Response to Planning application from Hertfordshire County Council (T and CP GDP Order 2015)

District ref: 6/2023/1433/COND
HCC ref: WH/17534/2023
HCC received: 14 July 2023
Area manager: Manjinder Sehmi
Case officer: Chris Carr

Salisbury Square Hatfield AL9 5AD

Submission of details pursuant of condition 2 (construction management plan) on planning permission 6/2021/3422/MAJ

Project	Date	JUN 2023
SALISBURY SQUARE OLD HATFIELD	Scale	1:200@A1
	Drawn	JT
Title	Engineer	AM
SITE ESTABLISHMENT DIAGRAM CONSTRUCTION PHASE	Project No	221111
Drawing No	Revision	
221111-CON-XX-00-DR-C-6001	P01

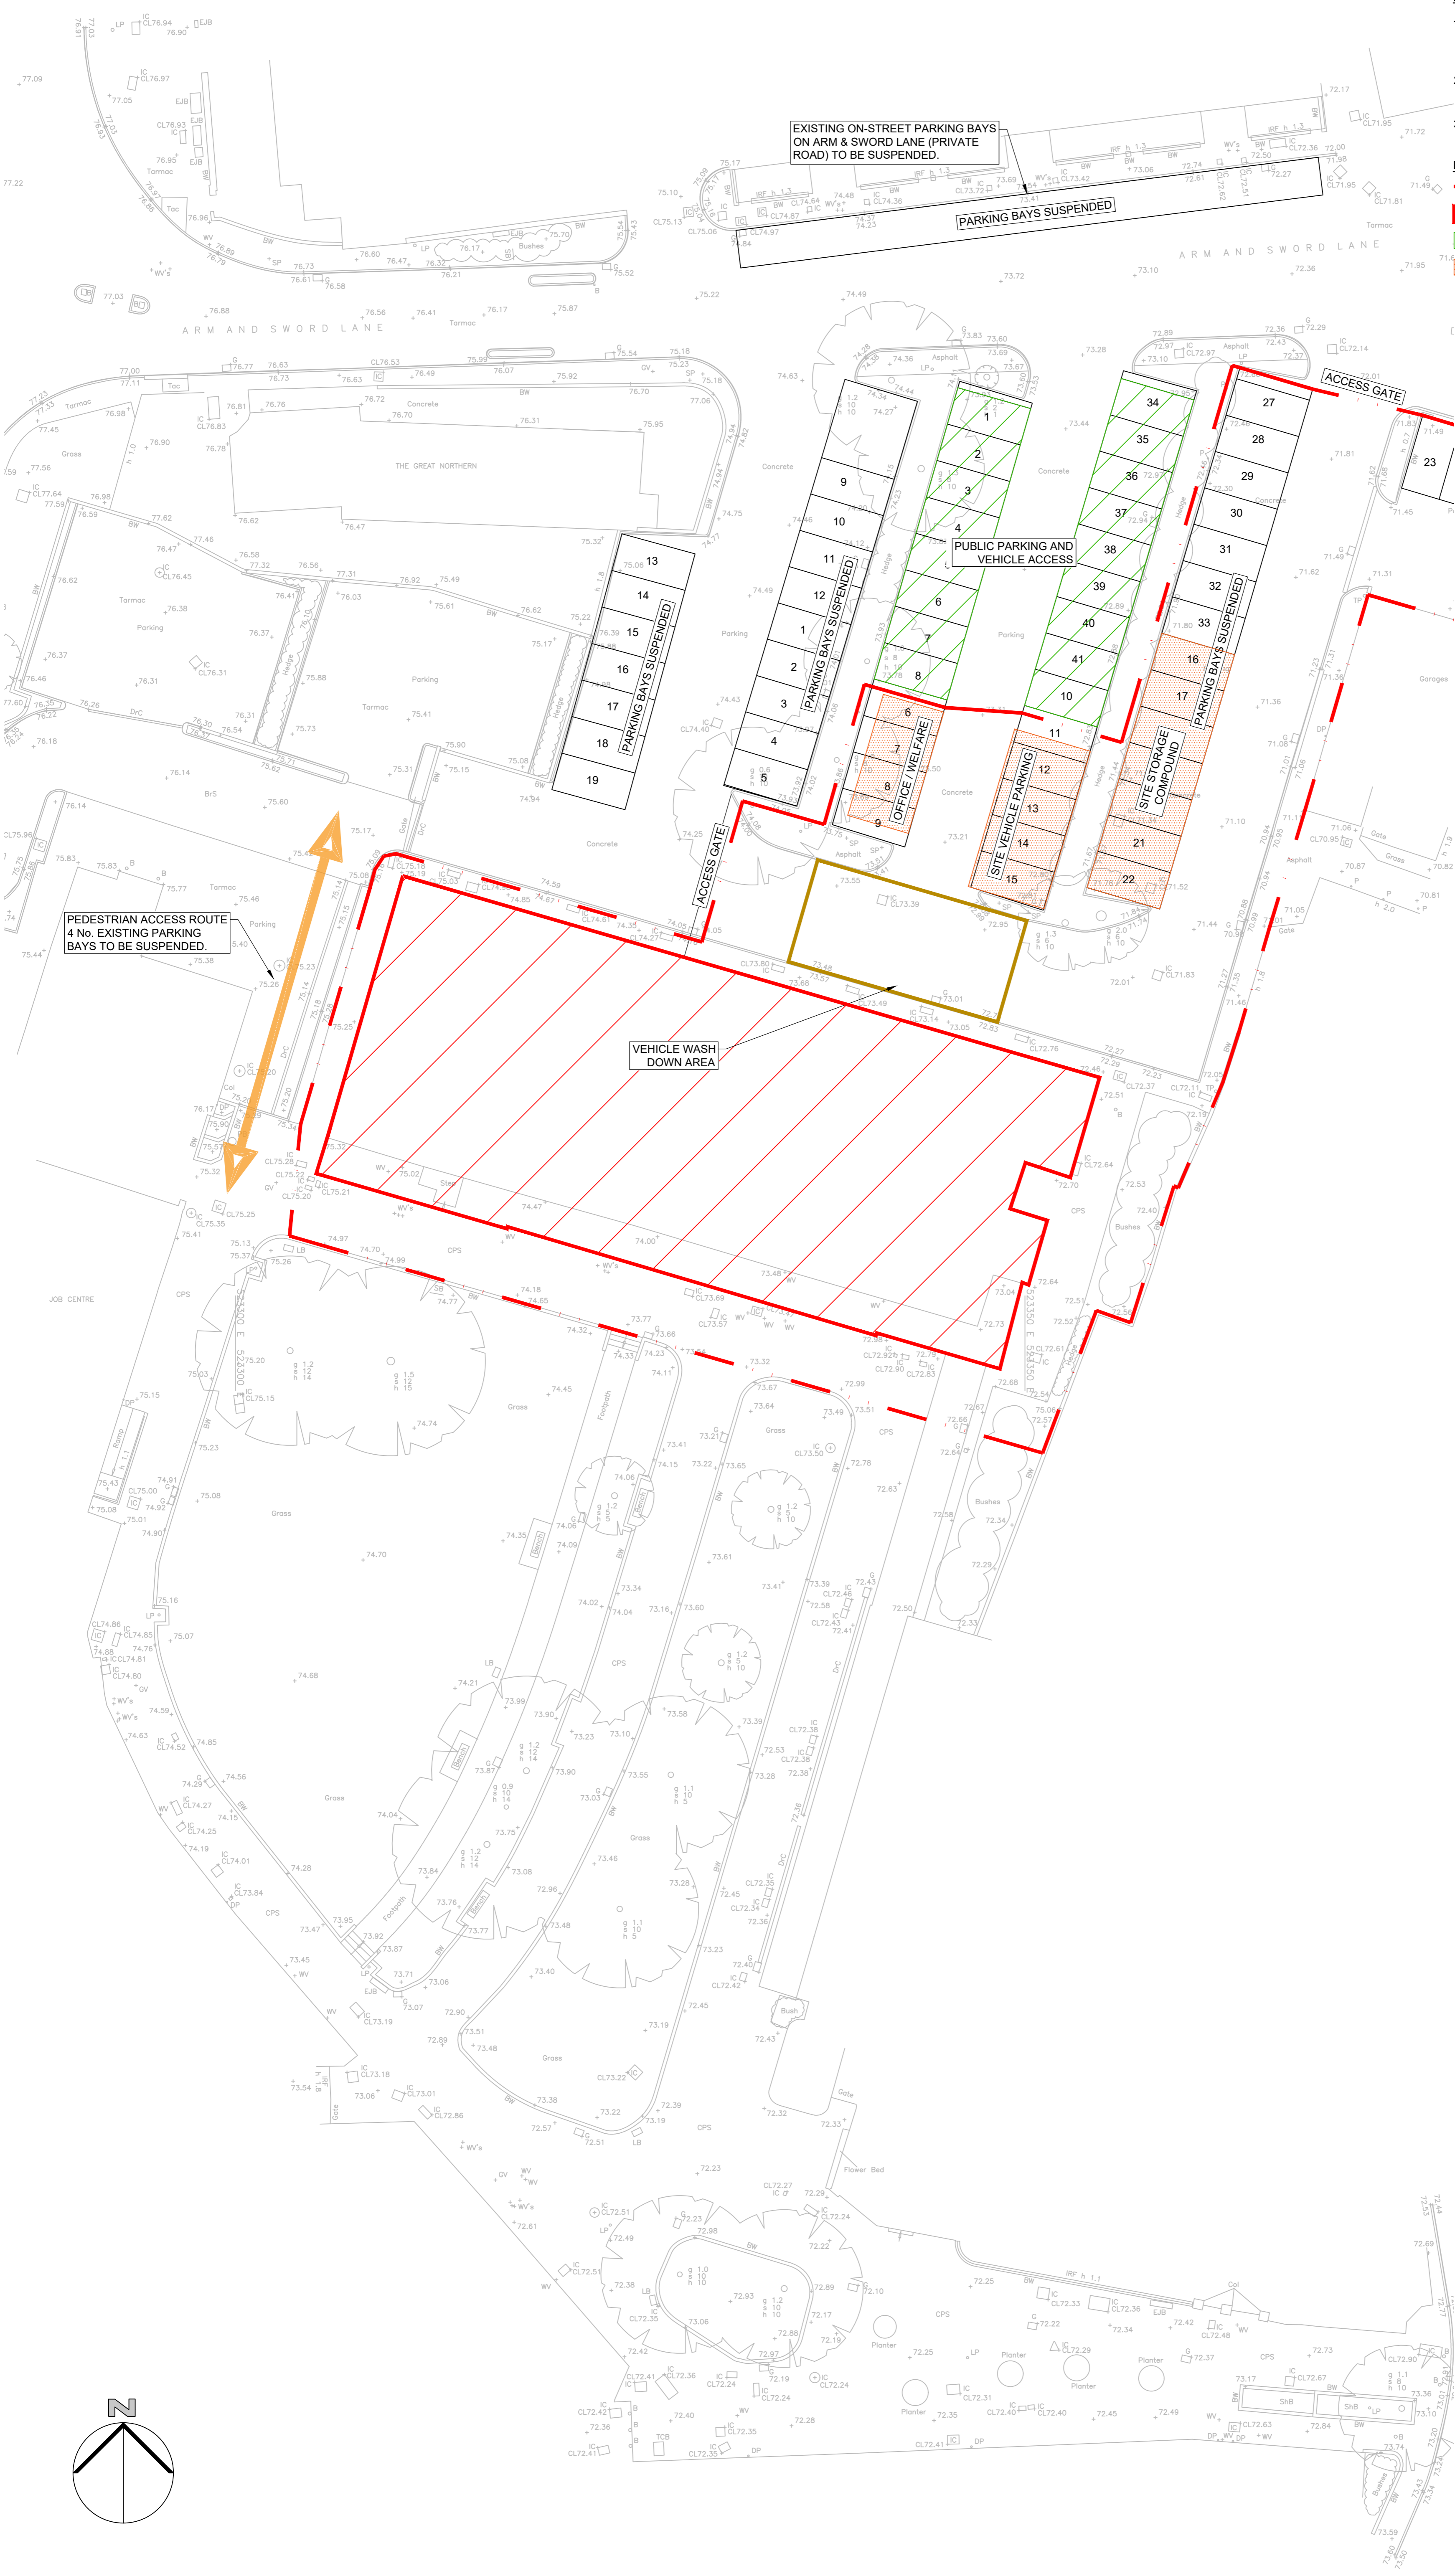
d) Submitted drawing 221111-CON-XX-00-DR-C-6000-P02 shows the location of 4 site vehicle parking spaces. There are no details of the proposed construction and storage compounds on this drawing however the CMP states that a figure within the CMP demonstrates the currently proposed site set up, including provision of storage / access arrangements for pedestrians & vehicles / temporary accommodation units / wheel washing facilities/phasing and parking area. This figure is not included within the CMP and this is required.
Conclusion: Condition 2 (part d) cannot be discharged at this time.

j) The CMP states (page 7) that a figure within the CMP demonstrates the currently proposed site set up, including provision of storage / access arrangements for pedestrians & vehicles / temporary accommodation units / wheel washing facilities/phasing and parking area. This figure is not included within the CMP and this is required.
Conclusion: Condition 2 (part j) cannot be discharged at this time.
